March 4, 2022

This letter is intended to serve as a comment response letter for the Amara Annexation, Master Plan, and Zoning initial review of the above requested application dated January 25, 2022. This letter is to accommodate the requested resubmitted plan and documents associated with the application.

**RE: Amara (Annexation, Mater Plan and Zoning) - Initial Review Comments**  
**File: CPC A 21-00197 - CPC A 21-00207, CPC MP 21-00208, CPC ZC 21-00209**

CITY FILE NO. CPC A 21-00207
610 N. Comstock Avenue, Suite 200
Orem, UT 84057
(801) 225-0790
(801) 225-0799 (FAX)

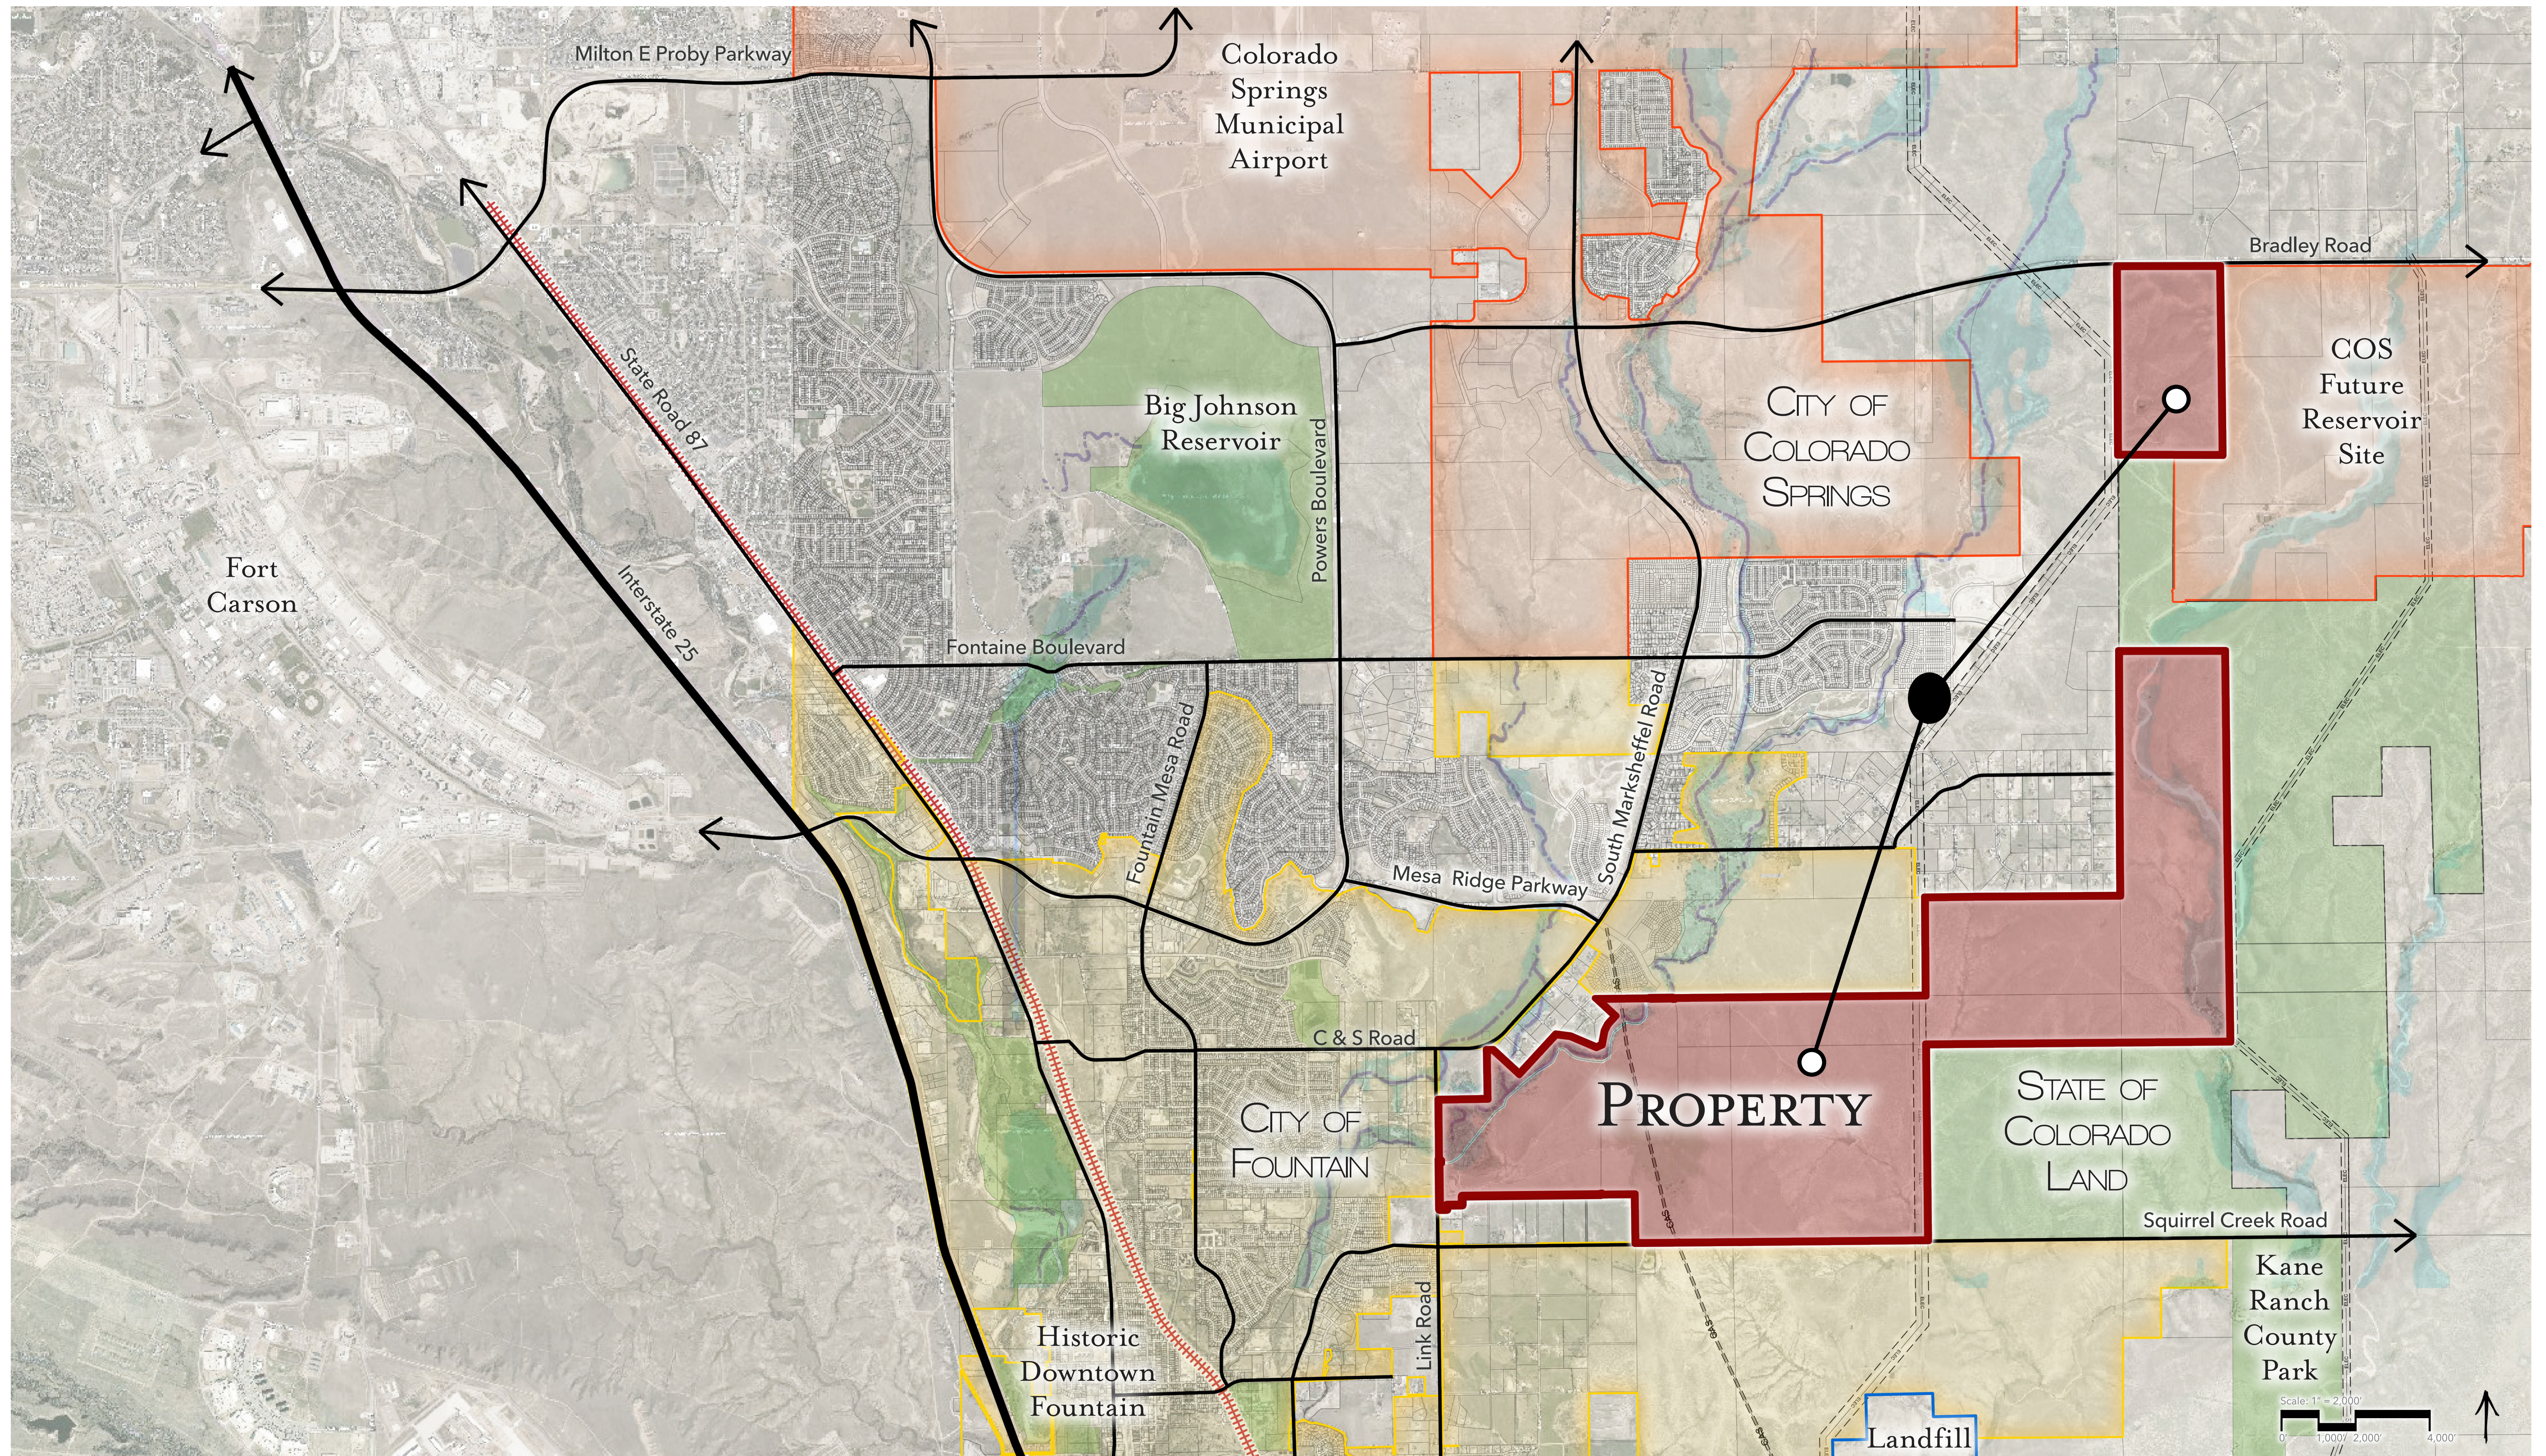
1. Please add the missing "be it known by these presents". - **Revised**

2. Please complete the City File No. CPC A 21-00207. - **Revised**
3. Please add the distance to the third course within the legal description (S 01-07-56 E 2629.96'). - **Revised**

4. When adding the area with a calculator the total perimeter is 30800.63', please verify. - **Revised**
5. Please add some additional section labels for section 26 and 27. - **Revised as possible**

6. Please label the lot numbers in Fountain Valley Land & Irrigation Co. Subdivision No. 1. - **Revised**
7. Please depict and label the Fountain Mutual Irrigation ditch as it cross the property and should tie into the canal as depicted on the adjacent plat to the south. - **Revised**

8. Please add the record information for Squirrel Creek Road. - **Revised**
9. Please check the line as depicted for the easterly line of the southeast quarter of section 33, as the monuments location lies easterly of the line as depicted. - **Revised**

10. Does Road Book A at Page 78 have any effect on any of these parcels being annexed? - **Revised as possible**

- **Response: See above responses for each number**
